Access Assessment Report

The New Primary School in Mulgoa Rise

Project:	The New Primary School in Mulgoa Rise
Reference No:	113966B-Access-MRPS-r5
Date:	17 August 2021
Client:	NBRS Architecture
Client Contact:	Johnsen Lim
Email:	johnsen.lim@nbsarchitecture.com
BCA Logic Project:	Alex Newberry
Direct:	0466 811 720
Email:	anewberry@bcalogic.com.au

Drawing Title
BLOCK B3 - GF PLAN

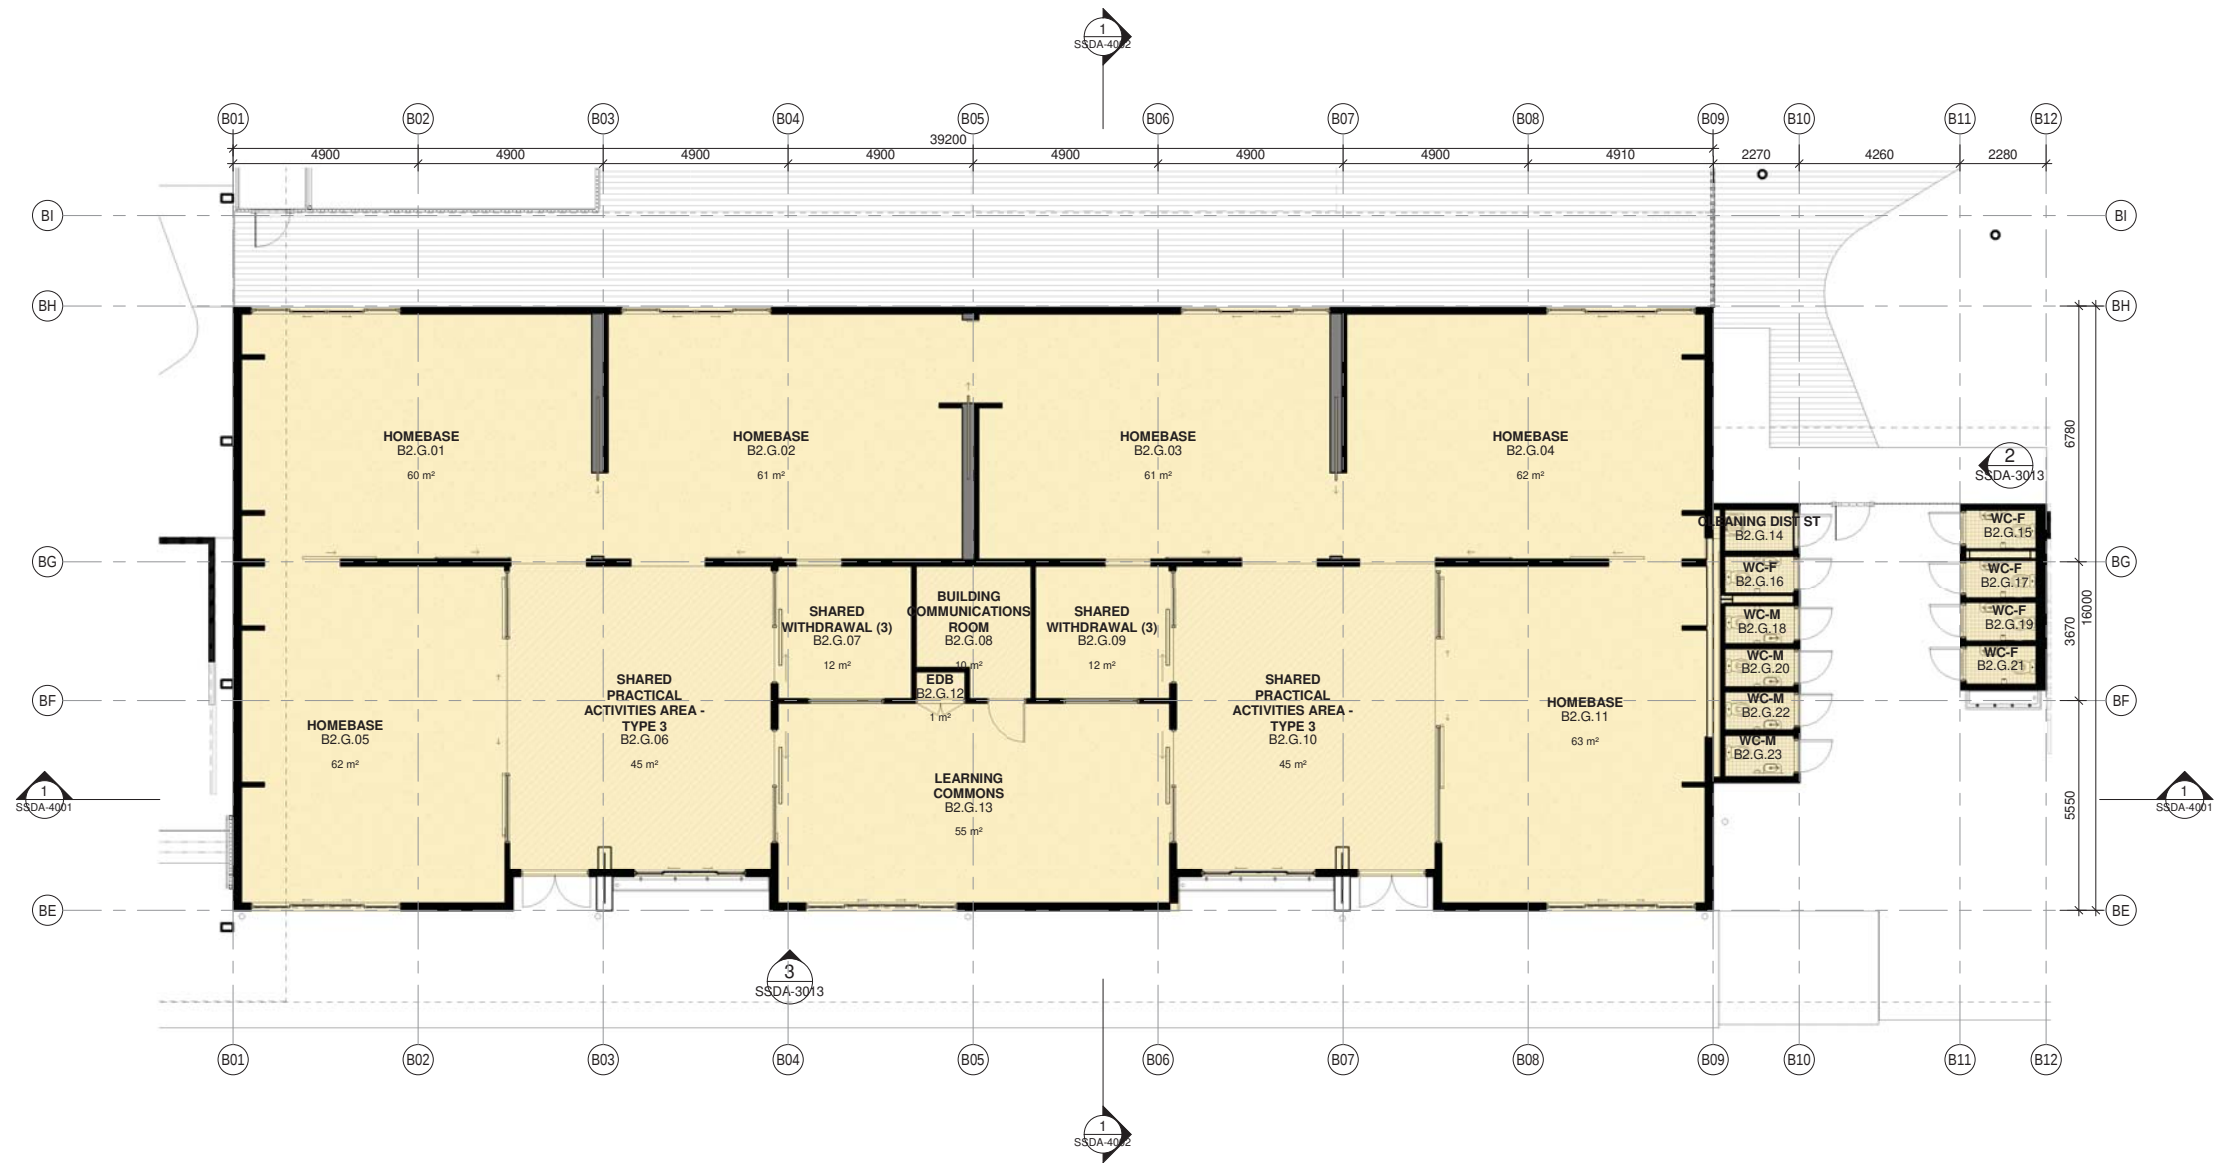
- Block B3 Ground Floor is an example below:
- Accessway shall be provided from both Shared Practical Activities areas then via internal accessible sliding doors into each Homebase. Refer Purple lines below for accessway into all accessible rooms. Internal sliding doors require 530mm latchside clearance which is not provided in current design.

- Rear northern Homebase sliding doors are required to be accessible to access courtyard decking. External sliding doors have challenges to being accessible: must have flush thresholds and have no more than 20N opening force. To be further reviewed.

- Internal sliding doors can generally achieve no more than 20N opening force for top hung doors with the correct sliding door hardware. Although, consideration should be given to size of doors and how to achieve 20N opening force.
